CITY OF ALBUQUERQUE

PLANNING DEPARTMENT – Development Review Services

April 29, 2014

**Re: Garcias Kitchen Food Prep & Catering
Grading and Drainage Plan
Engineer's Stamp Date 4-16-2014 (J13/D096)**

GRADING AND DRAINAGE PLAN

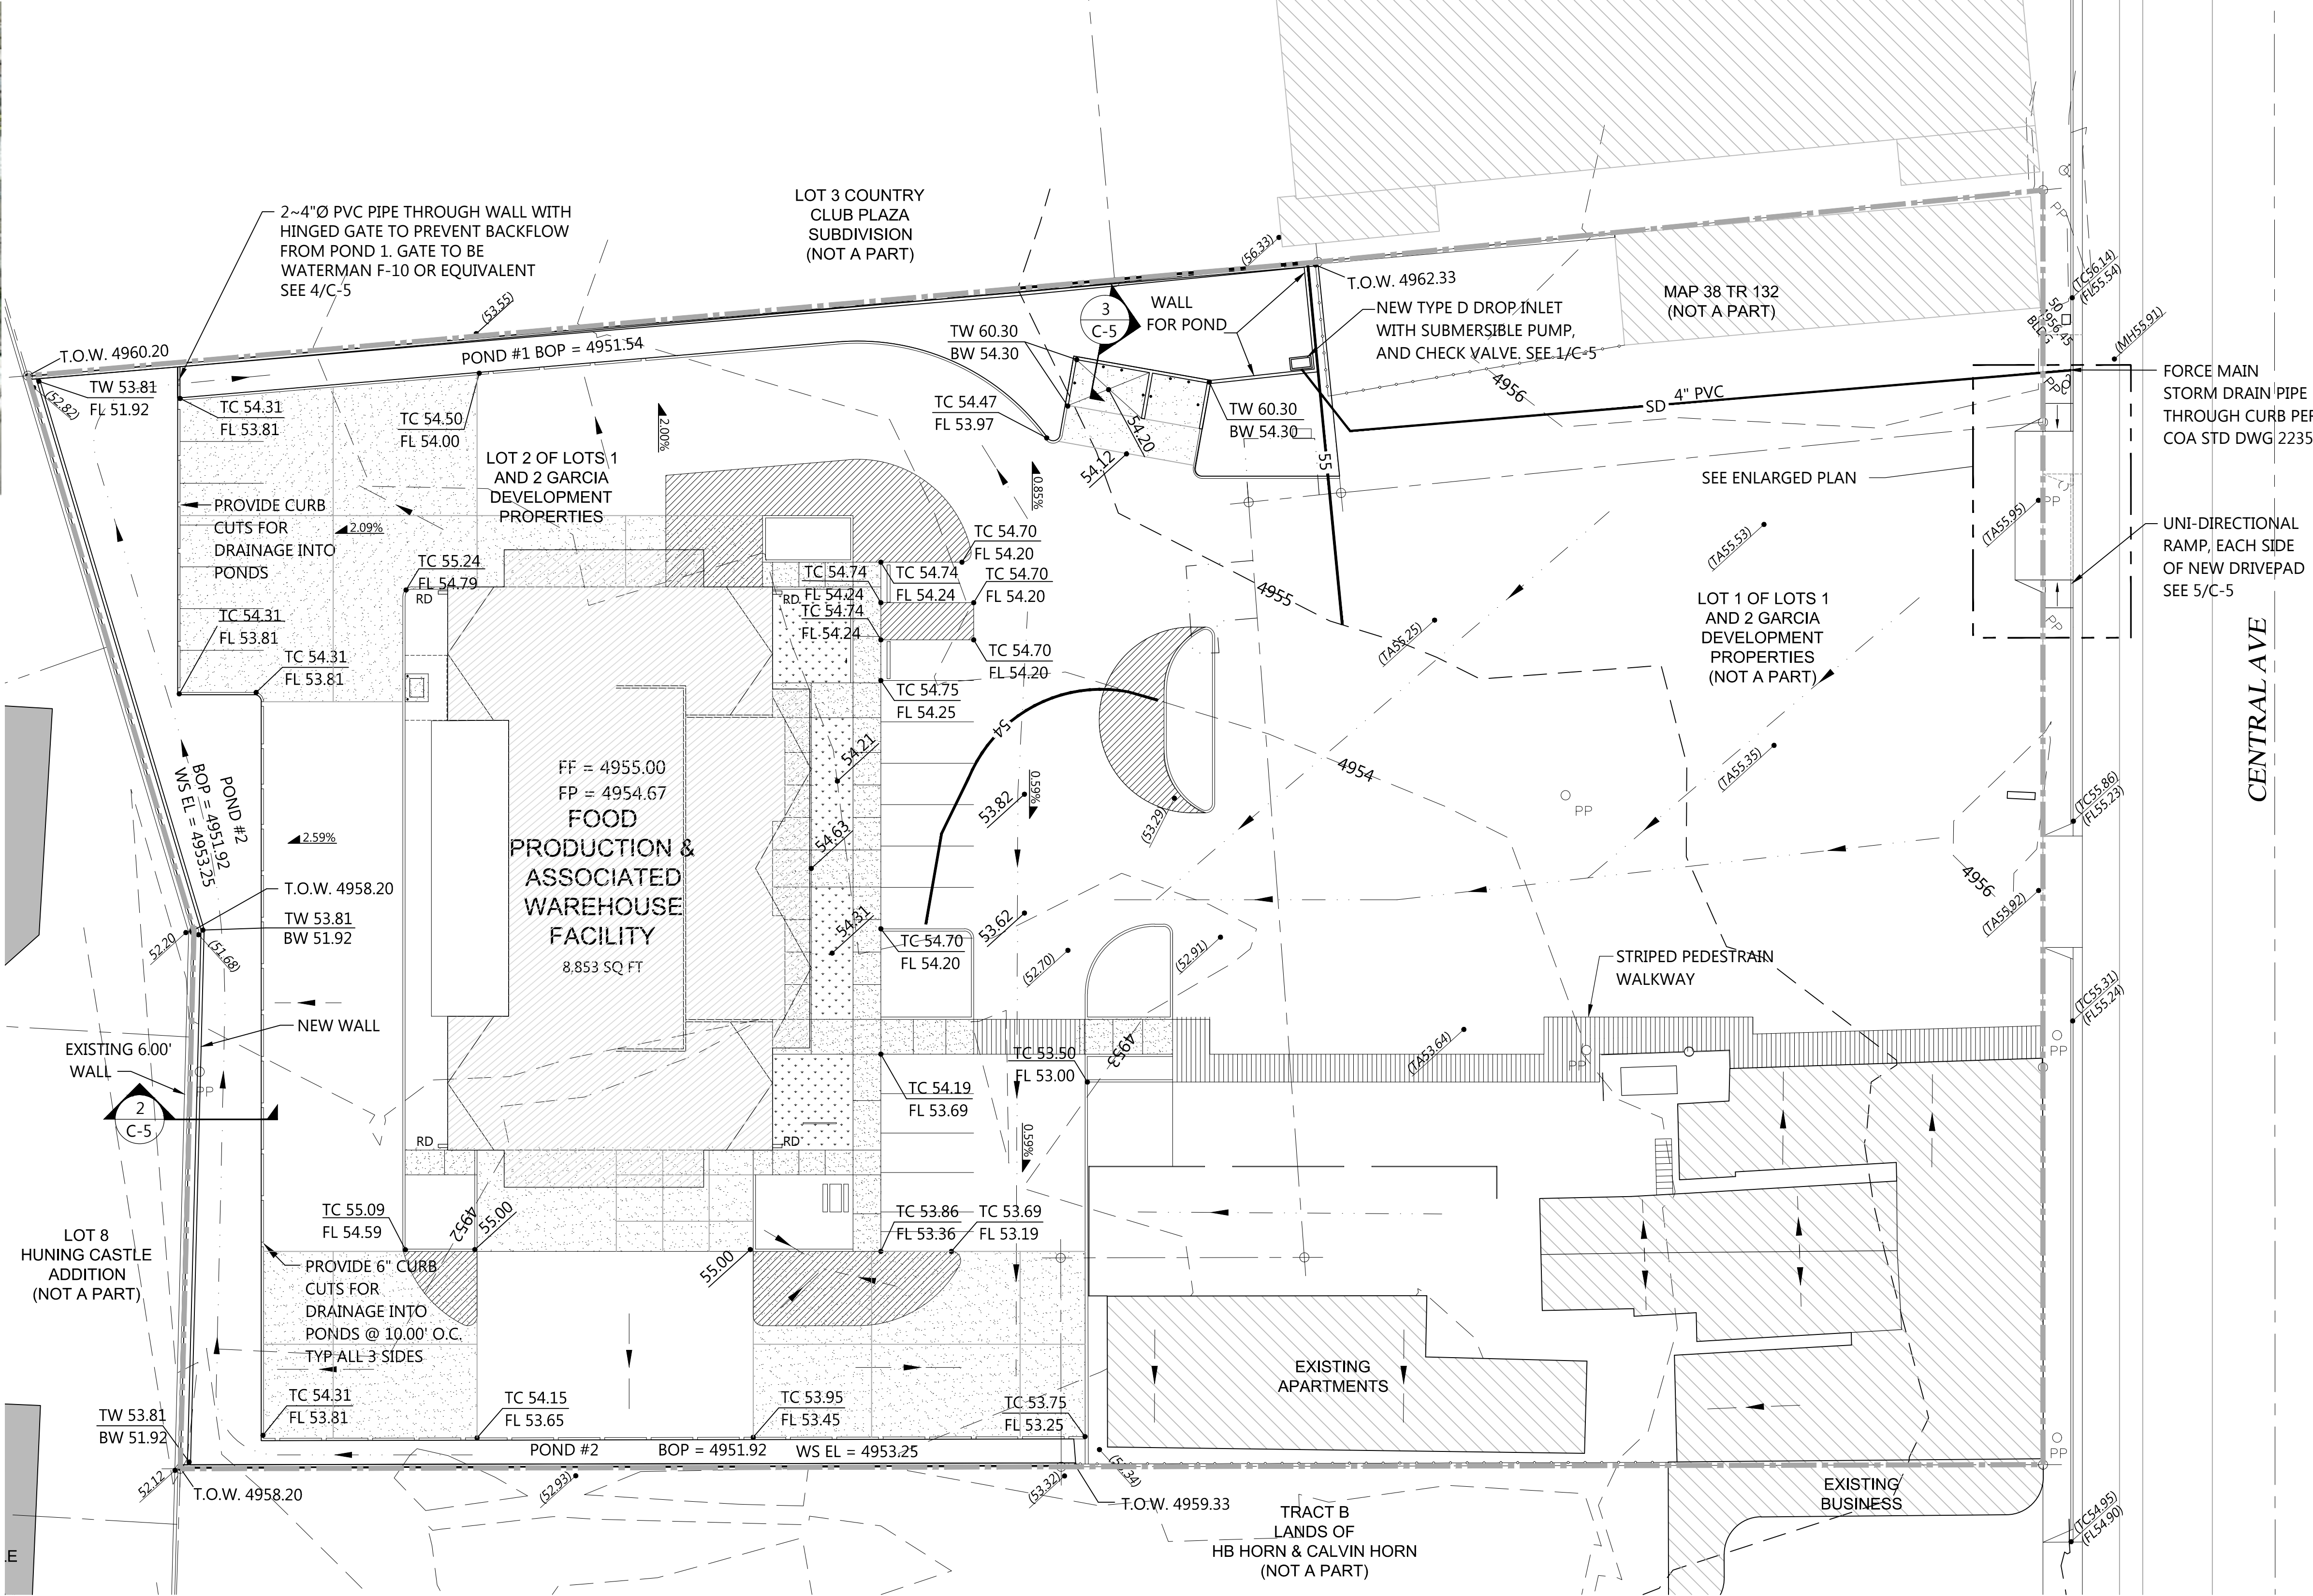
1. Please quantify the offsite flows. The drainage narrative states there is offsite flow from the existing restaurant. Are flows from the adjacent apartments included? If not, give an explanation. Lot 1 clearly drains into the proposed site. Is the entirety of Lot 1 included in the basin boundary? Or only portions there of? Delineate the basin boundary used in the analysis. As shown, the flows from restaurant (and possibly apartments) are not able to drain to the pond due to curb.

2. Clarify existing and proposed spot elevations along the boundary lines. The street flow from the Central should not be flowing into the site. In order to verify that this is in fact the case, spot elevations and flow line elevations are needed at driveways, curb cuts, and waterstops.

3. While pond volumes are shown, Pond #2 and Pond #3 have same BPEL and should be considered one and the same pond. What is the meaning of the line that separates them?

4. Pond #1 Volume calculations are dependent on the pump discharge rate. Provide calculations and show the WSEL for all the ponds.
5. Please include a note on the grading plan that floor drain of the trash enclosures will be routed to an oil water separator and then to Sanitary Sewer.

7. Positive flow away from the building is shown, but indicate where the roof is draining.
8. Curb opening along the south pond is shown but not on the westerly and easterly ponds. Curb openings should be sized and located using dimensions.

9. Erosion Sediment Control Plan must be submitted prior to building permit approval.
10. A backflow check valve will be required before the SD passes thru curb. Plans must also indicate that the connection will be built through a work order.
11. It is unclear what is meant by "Wall with 2" - 4" baffles" at west wall. Is this a weir?
12. Provide Sump Pump cut sheets showing pump curves.
13. If pump fails, an emergency overflow path should be indicated, preferably where "Wall with Baffles" is noted on the plans.

DETENTION POND DETAIL

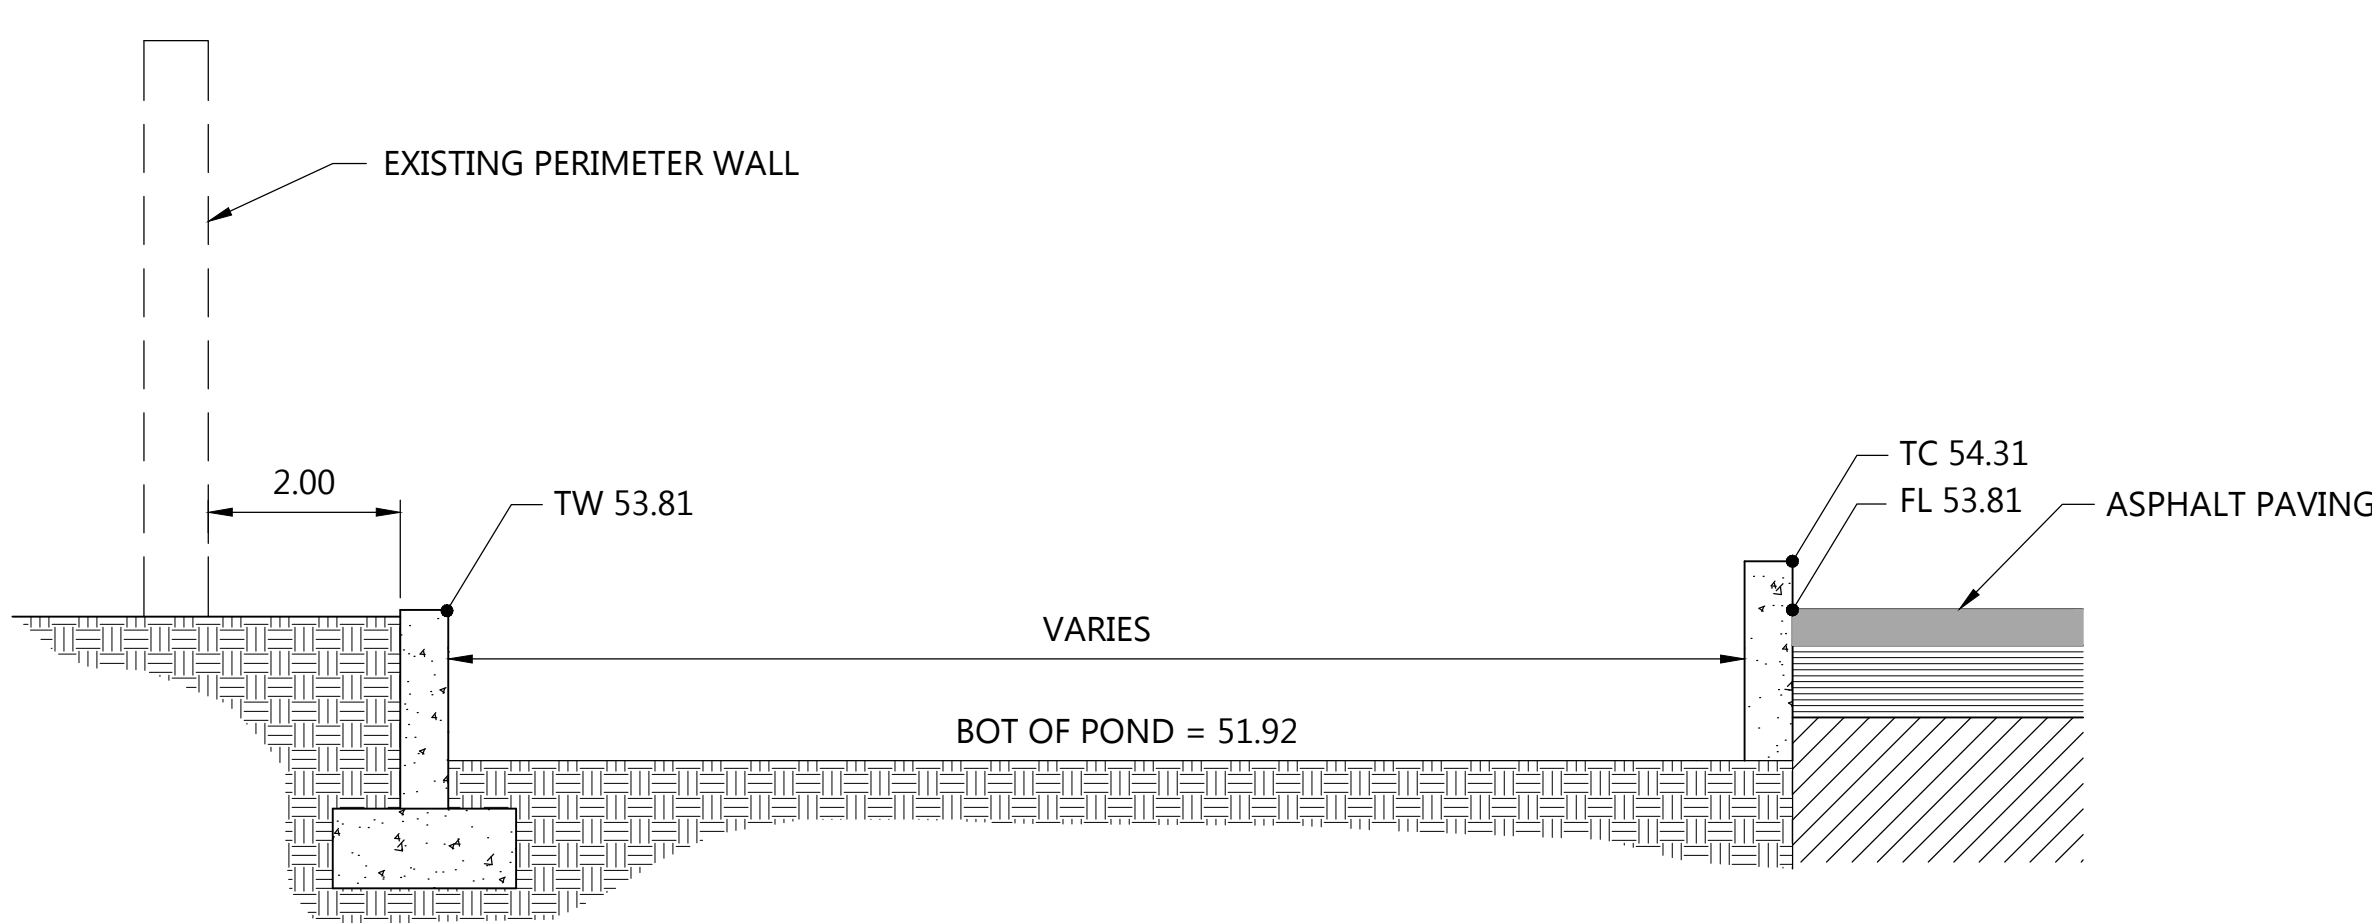
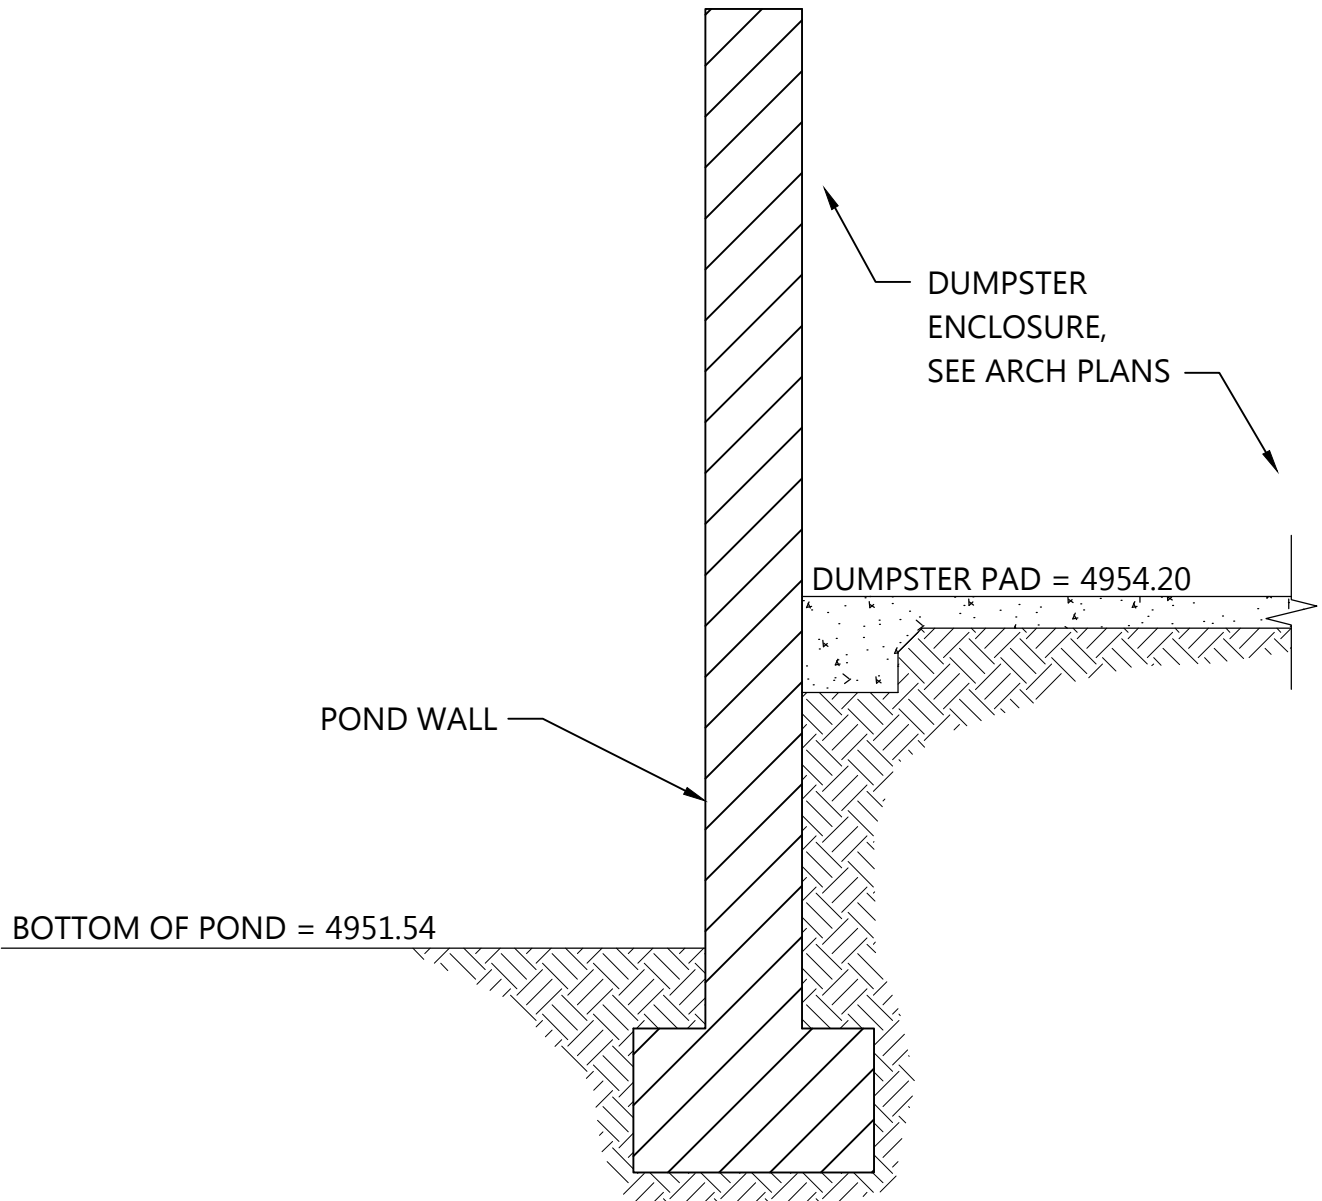
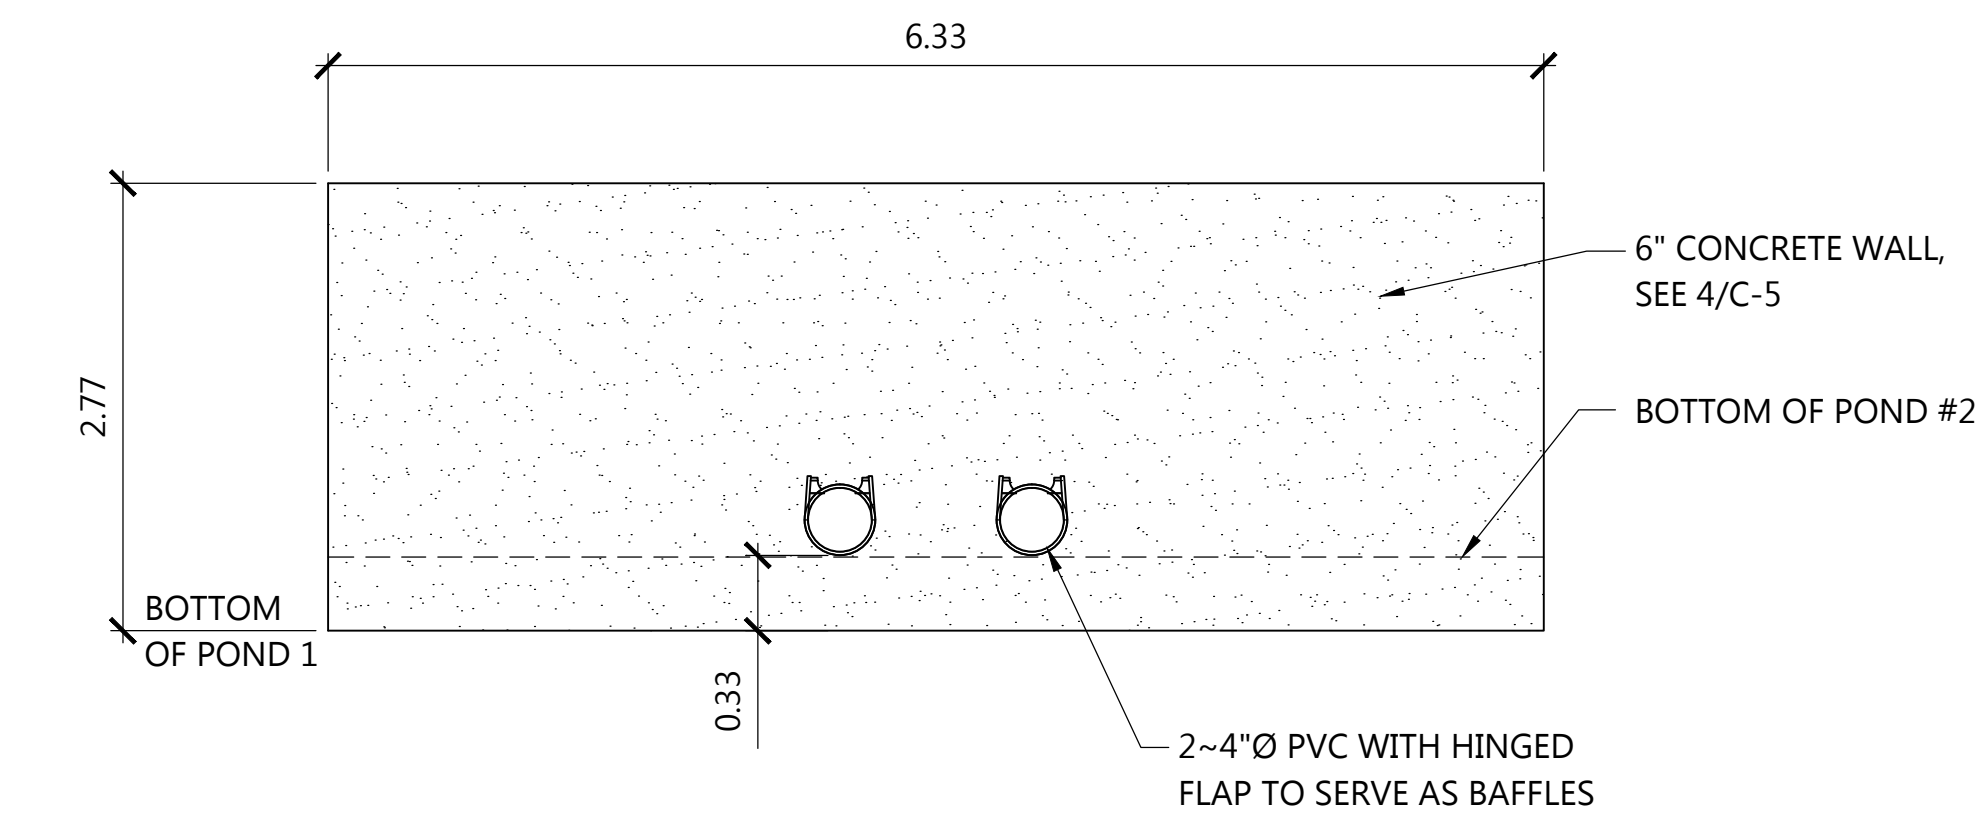
6. Include cross-sections of Ponds No. 1,2, and 3. Detention Pond detail 1/C-1 shows a partial section, but does not show its relationship to the trash enclosures. On the south side, the cross-section should also show the relationship of the existing wall to the new wall. TOW elevations are not shown for the new wall. Will the retaining walls be waterproofed?
